East Anglia ONE North and East Anglia TWO Offshore Windfarms

Applicants' Comments on Tessa Wojtczak's 11 Submissions

Applicant: East Anglia TWO and East Anglia ONE North Limited
Document Reference: ExA.AS-28.D12.V1
SPR Reference: EA1N_EA2-DWF-ENV-REP-IBR-001127

Date: 28th June 2021
Revision: Version 1
Author: Royal HaskoningDHV

## East Anglia ONE North

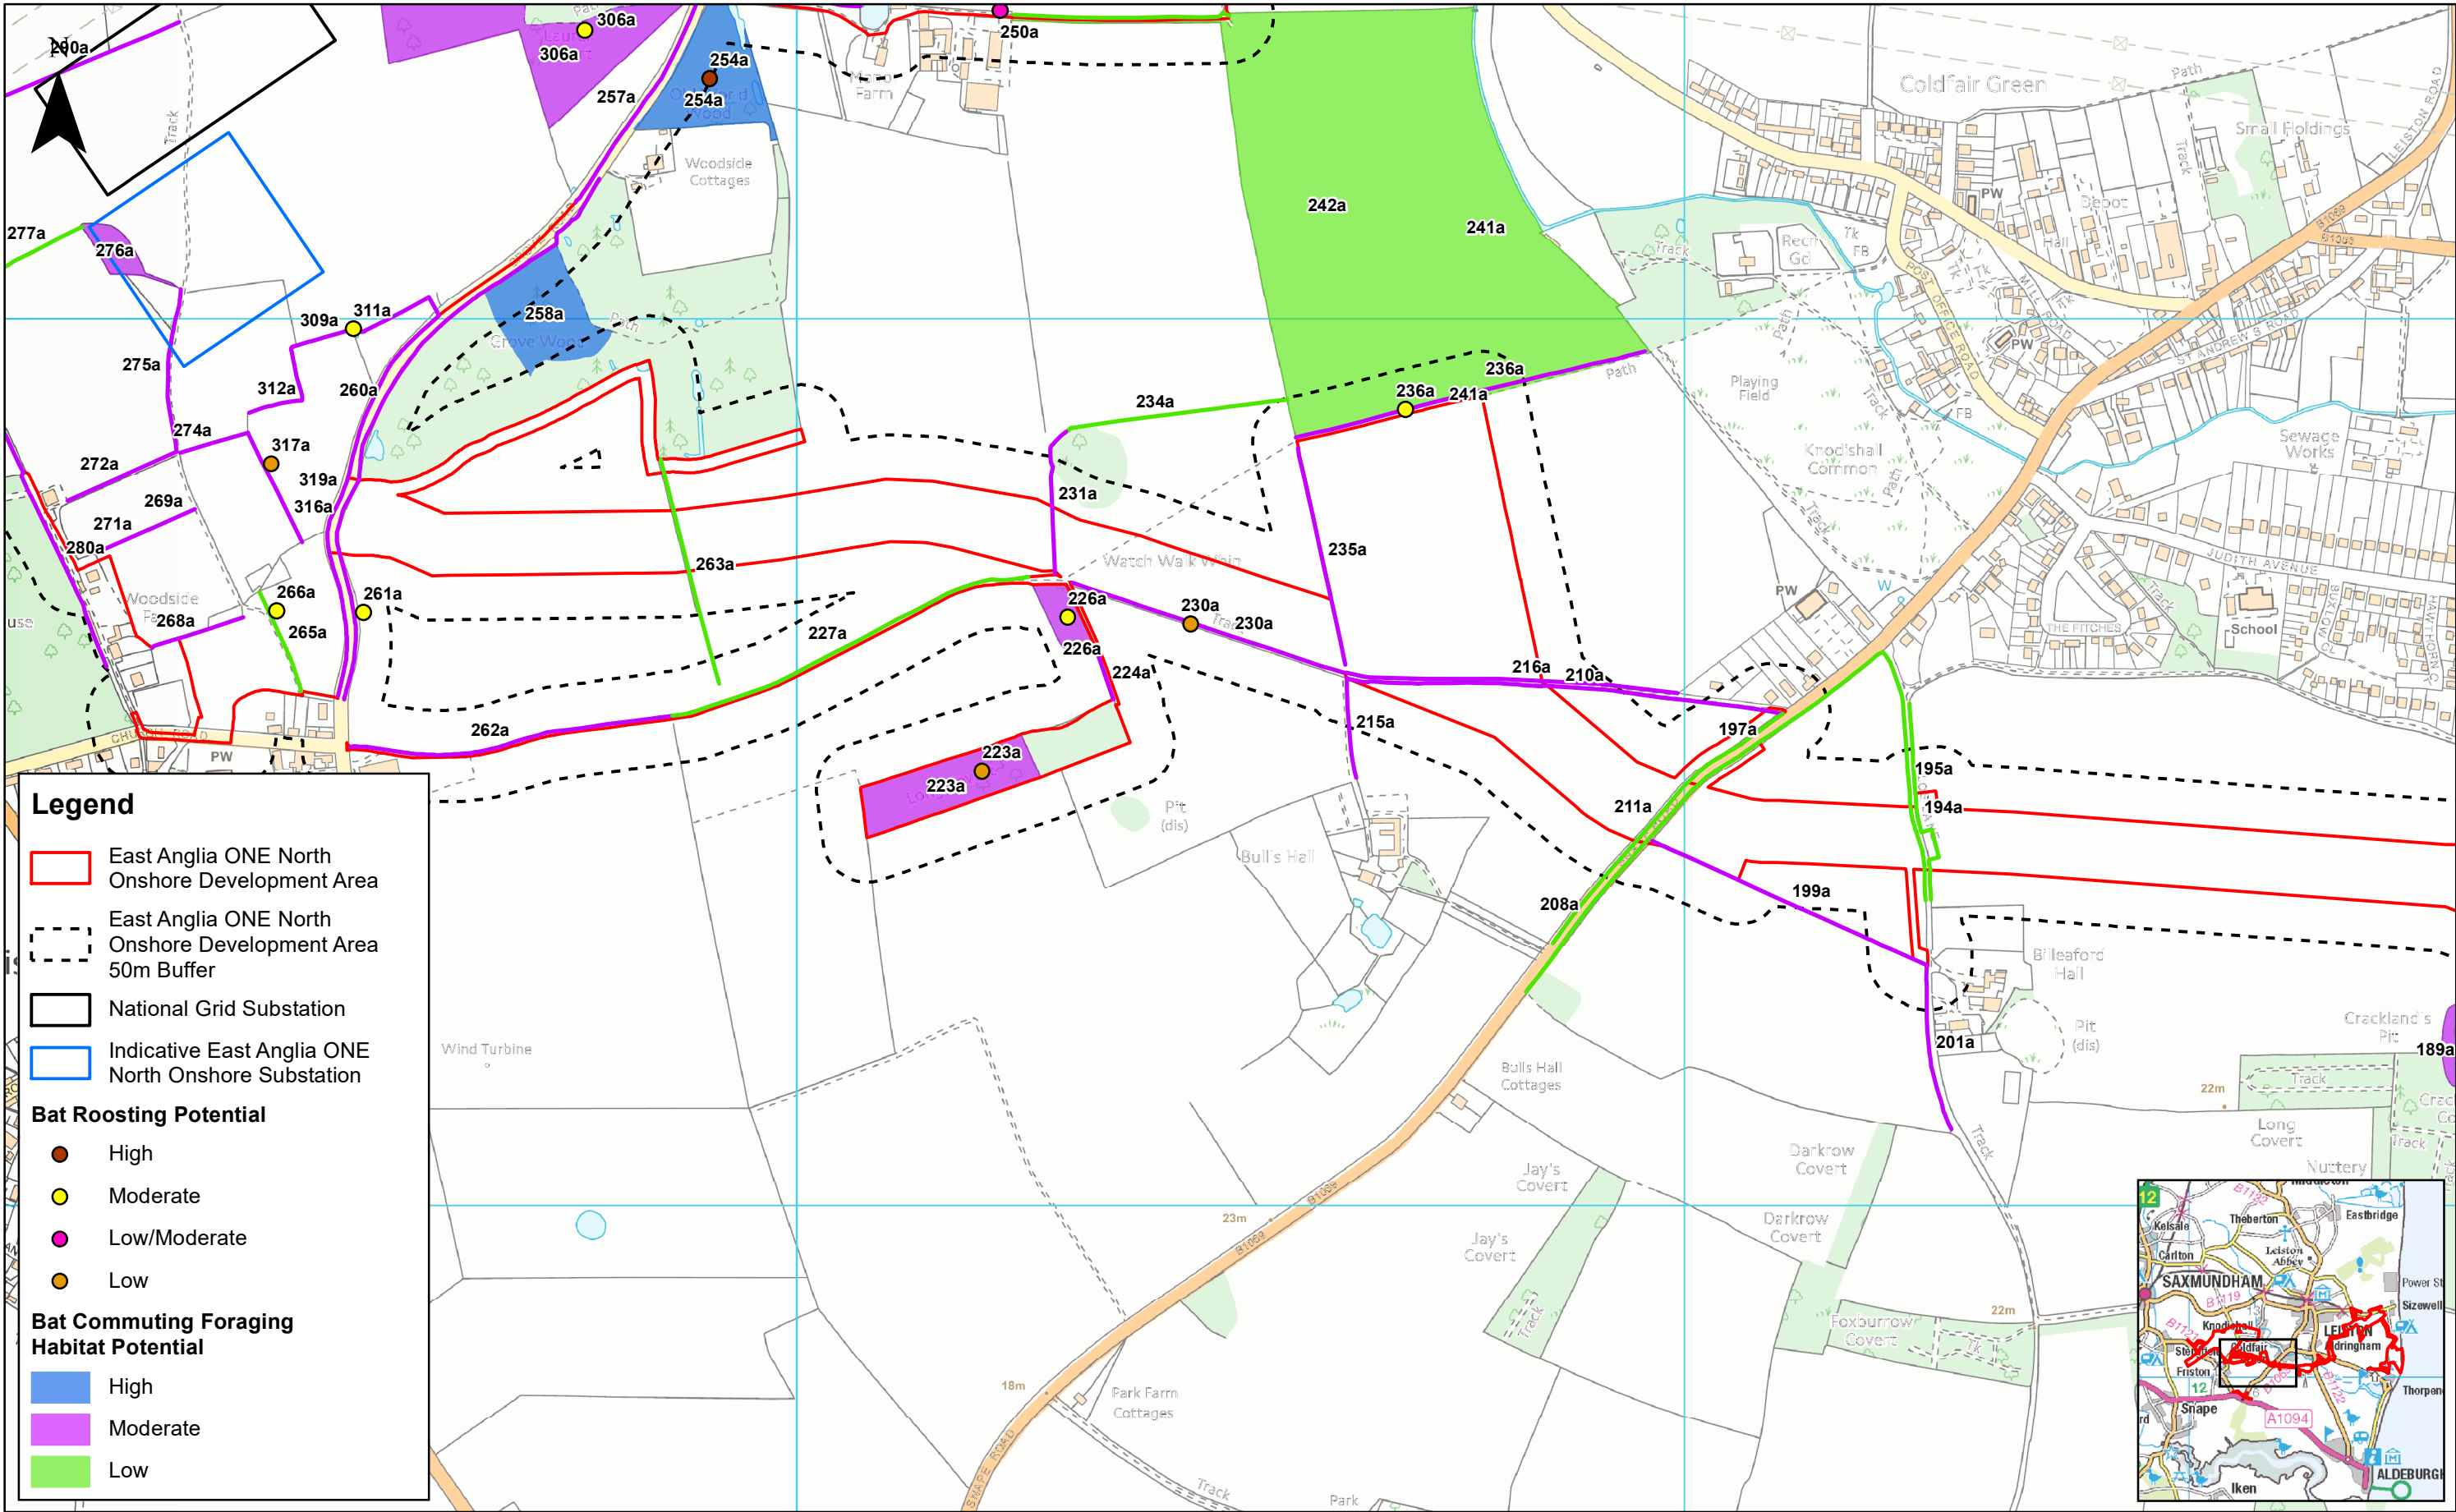
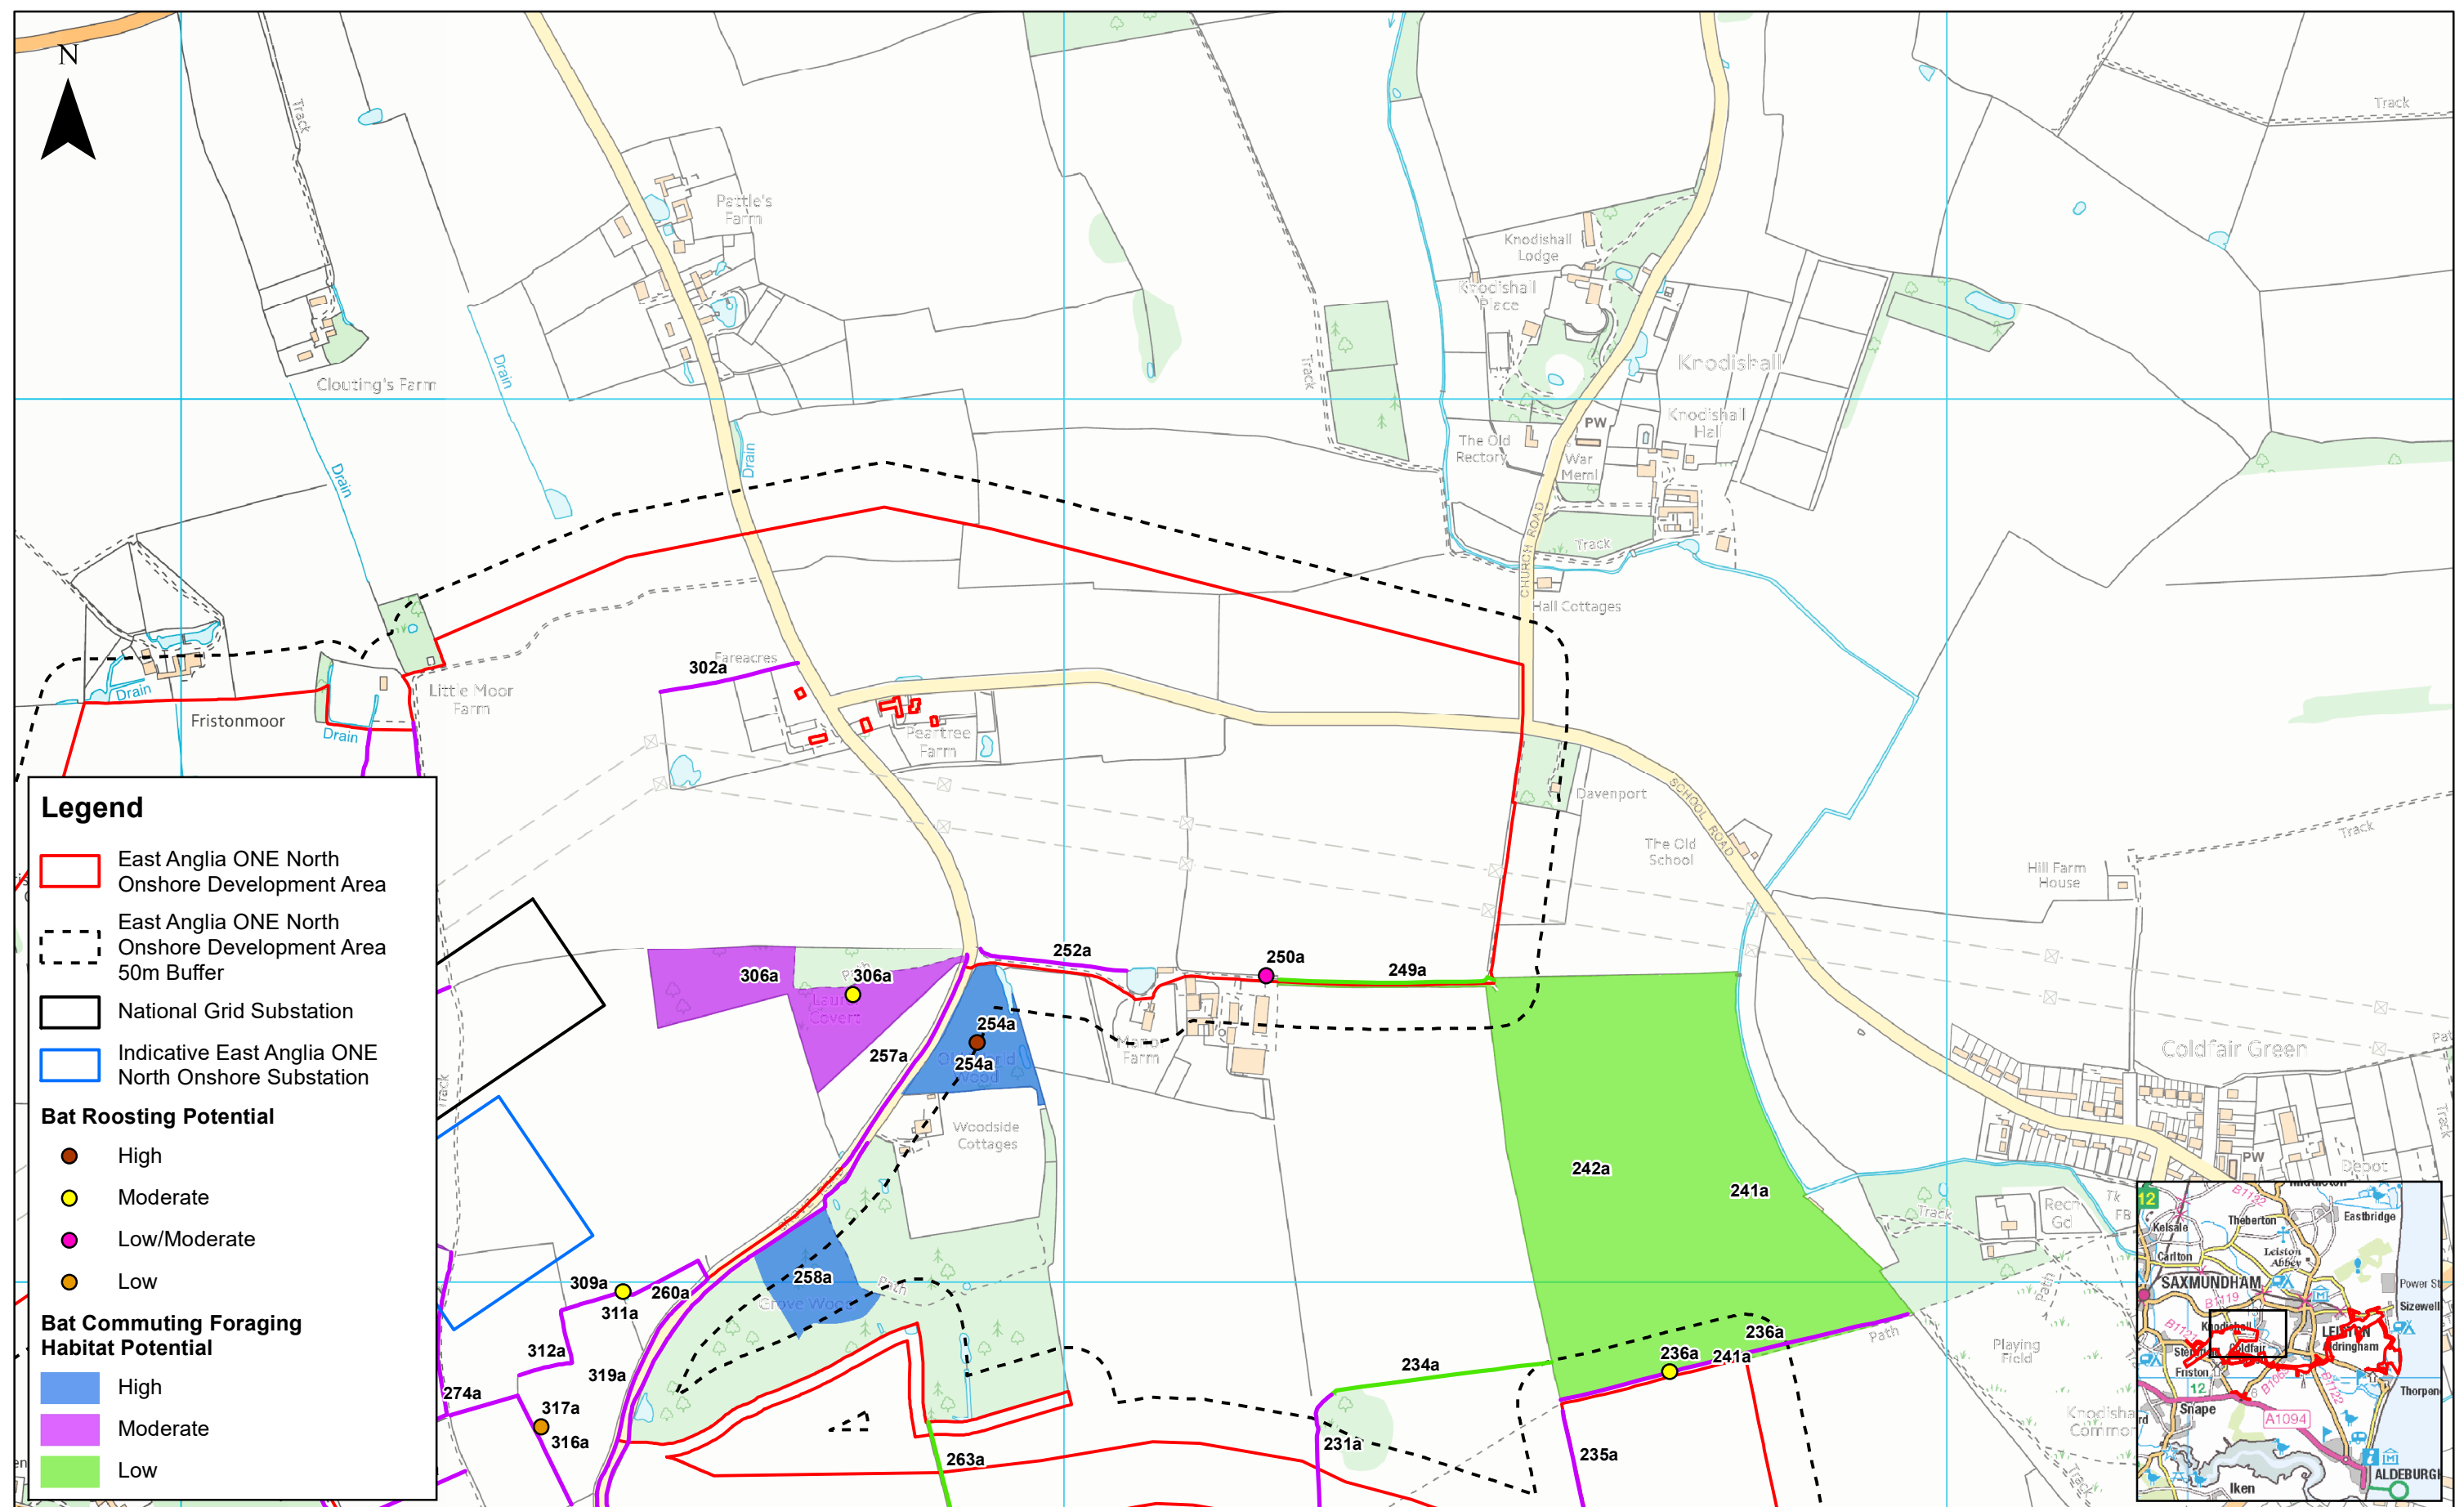
9	<p>Impact 9 , Bats states that no confirmed bat roost sites have been recorded within the Onshore development area.</p> <p>This in itself is remarkable given the extent of that area. However, the Applicants translates that lack of recording of confirmed bat roost as a conclusion as “an absence of this species at this location.”</p>	<p>Ms Wojtczak misrepresents the information within Change Request: Amendment to Order Limits at Work No. 9 (Plot 13) (AS-104). Where practicable, development of the Order limits sought to avoid environmental sensitivities (e.g. potential bat roosts). AS-104 notes that bat activity was observed during surveys across the onshore development area, and that foraging / commuting bats were detected at survey locations near to the coast.</p> <p>The area of land brought into the Order limits by the realignment has no bat roost potential (being the centre of an intensively farmed arable field). There is a single hedgerow (potential bat commuting feature) present within this stretch of</p>

ID	Tessa Wojtczak's Comment	Applicants' Comments
	<p>At present there is, as there is every year, constant and prolific activity of pipistrelle bats in our garden, along the track and across all the fields adjacent. It is a false conclusion; and yet it stands</p>	<p>the Order limits; the realignment will require the removal of a shorter section of this hedgerow than previous. Therefore, the assessment conclusions regarding bats within Chapter 22 Onshore Ecology (APP-070) remain valid.</p>
10	<p>Impact 10. Great Crested newts (which we have observed, apparently emerging from Plot 13 and approaching the pond at Wardens). The Applicants state that “ aquatic habitats are not present at this location “.</p> <p>The Panel has seen the wildlife aquatic pond directly over the fence from Plot 13 at Wardens; not within the Order Limits, but surely of significance in this respect as habitat for Great Crested Newts. Again, the statement does not reflect the reality, and yet it stands within the ES.</p>	<p>See Applicants' response at ID8.</p>
